89 Anderson St., BP# 2016-02351 plan review comments

I have completed the review of this permit for building codes and have the following comments:

**1 FLOOR PLAN**  
1/2" = 1'-0"

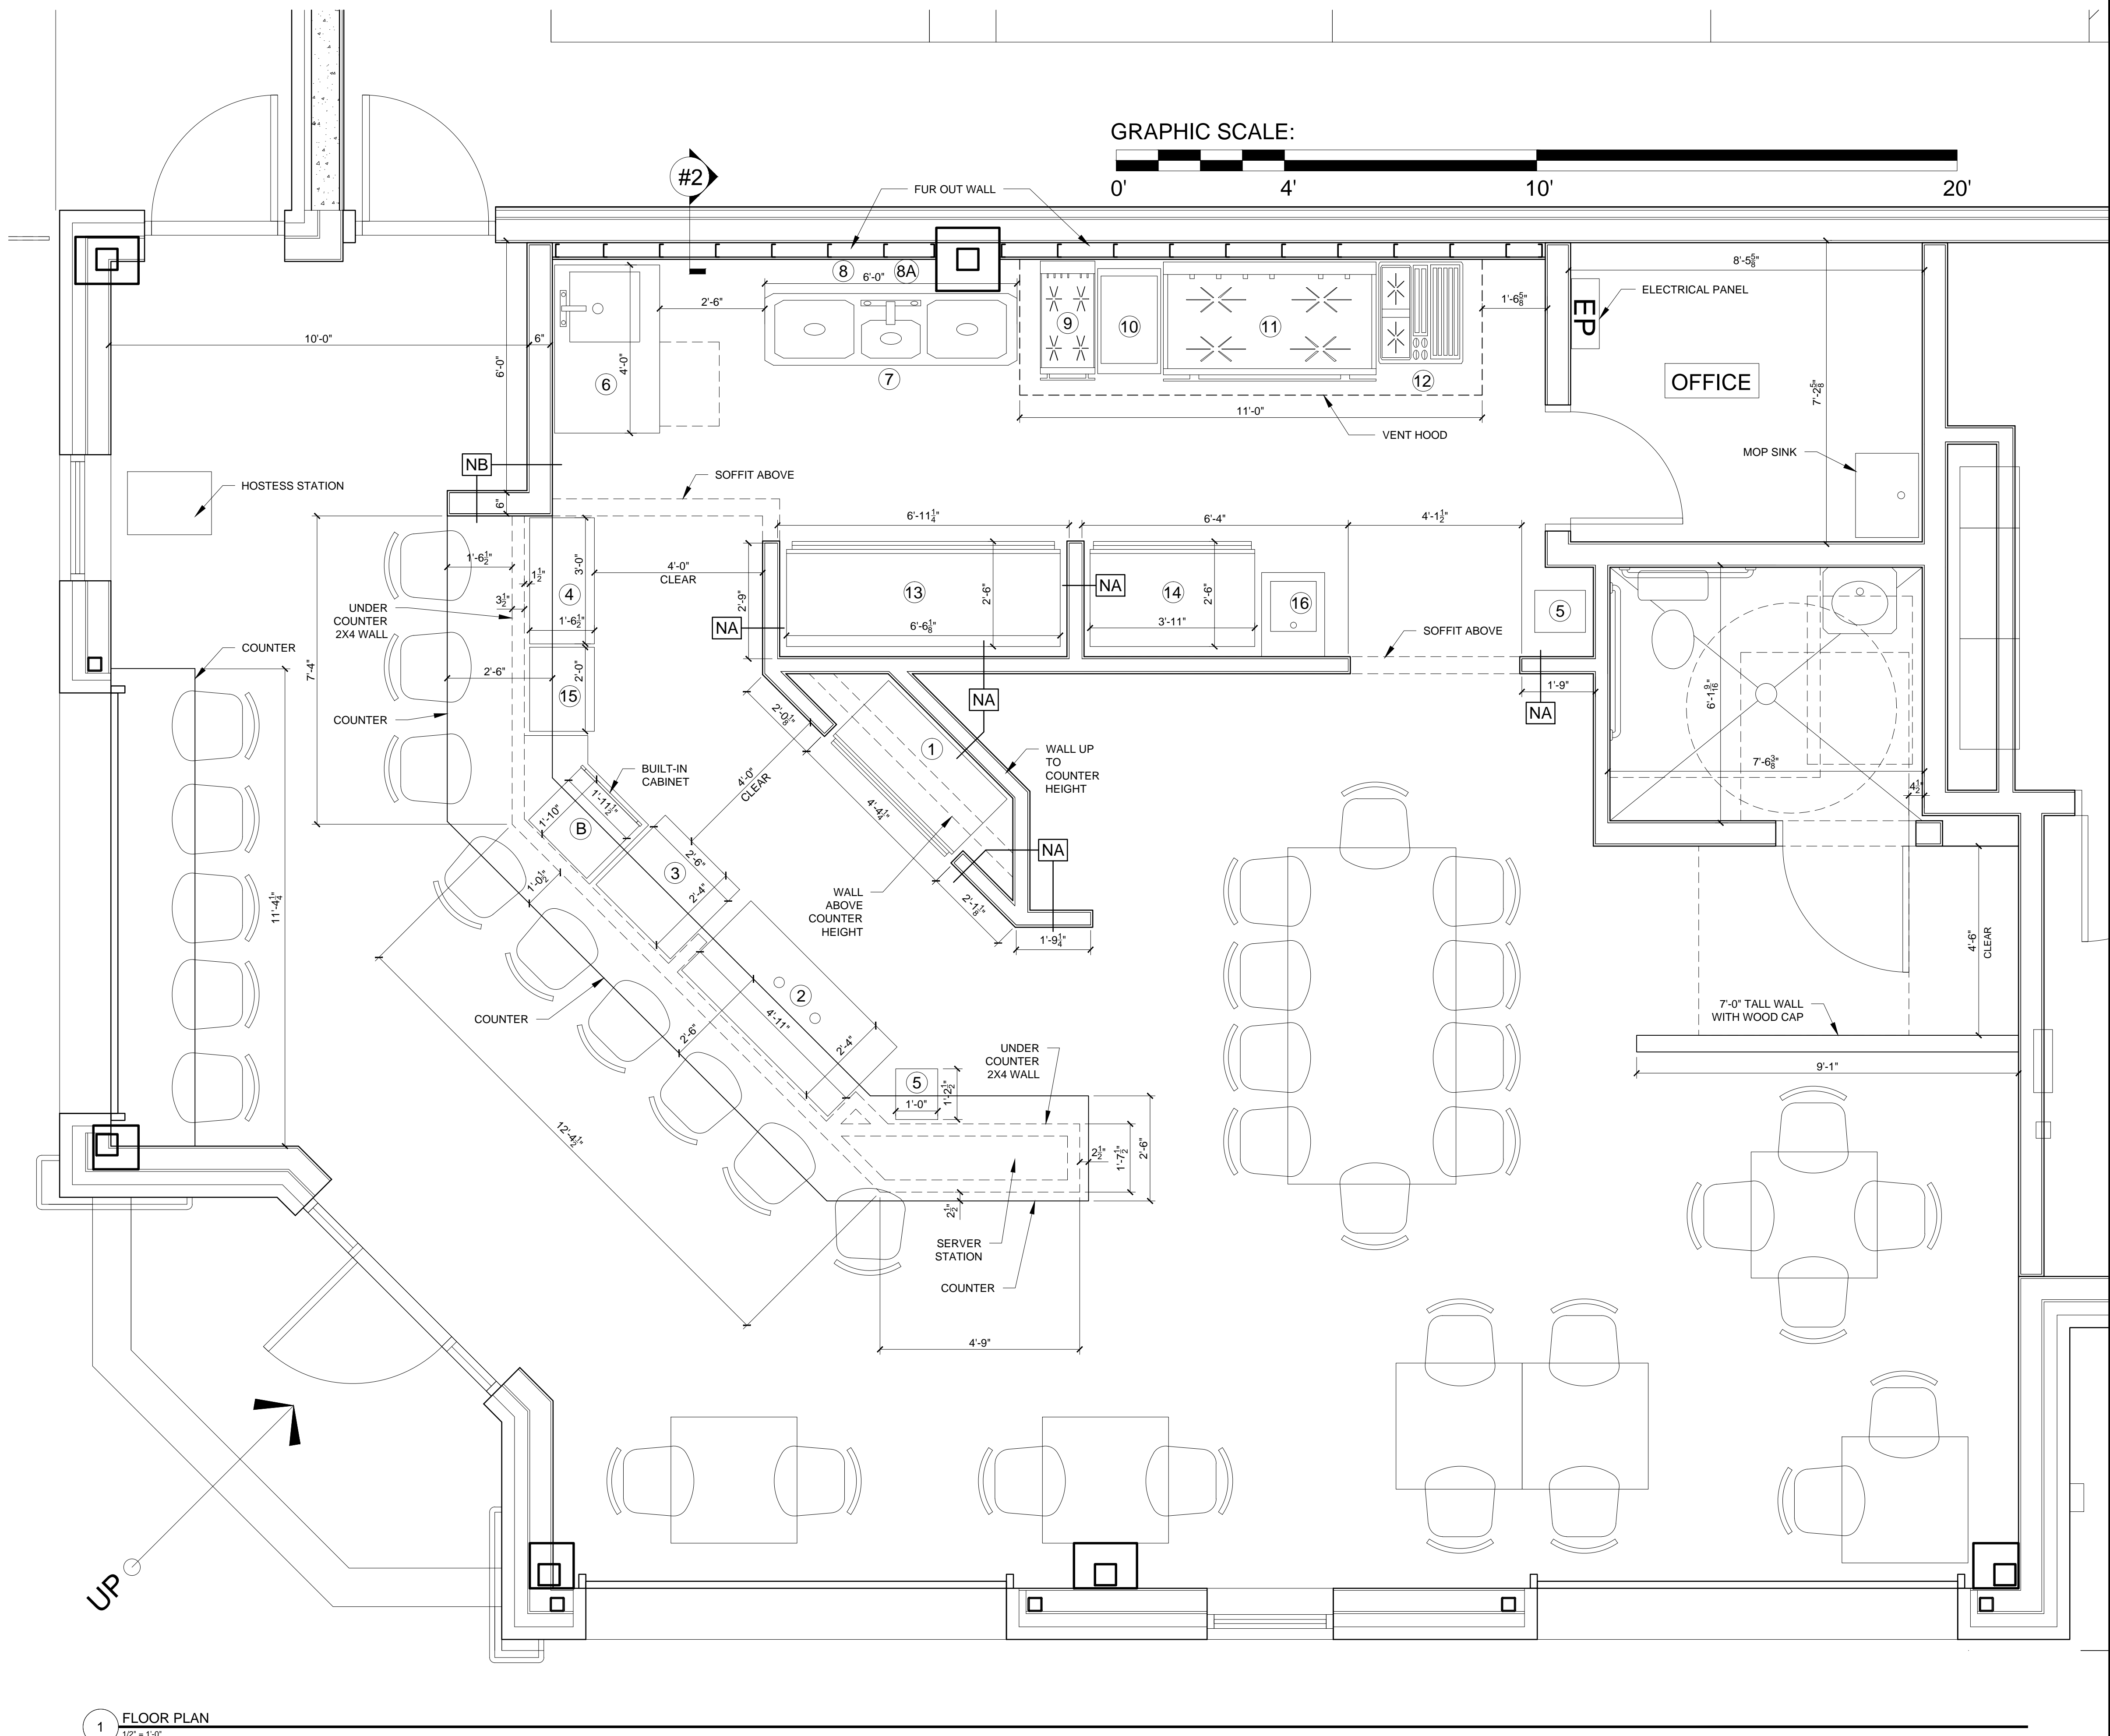
1. A floor drain is required in the kitchen wash area.
2. For the overhead doors, the Food Code requires protection from insects when present when the doors are open. This can be accomplished with screening, which is unlikely in this situation, so the other option is the installation of air curtains. If you have any questions on this you can contact Tom Williams at tw@portlandmaine.gov.

Hi Jeanie. Clay is going to confirm that there is a floor drain in place currently. There will be insect protection. Clay has committed to at least having insect screens installed but is exploring the cost of air curtains. Is that adequate for issuing the permit? Or do you need a proposed plan for insect protection?

Just received confirmation that there is a floor drain in the kitchen space currently.

Thank you for confirming these items. I will put a condition of approval about the insect mitigation so it is on the record and leave it to the health inspectors to follow up with this when they inspect.
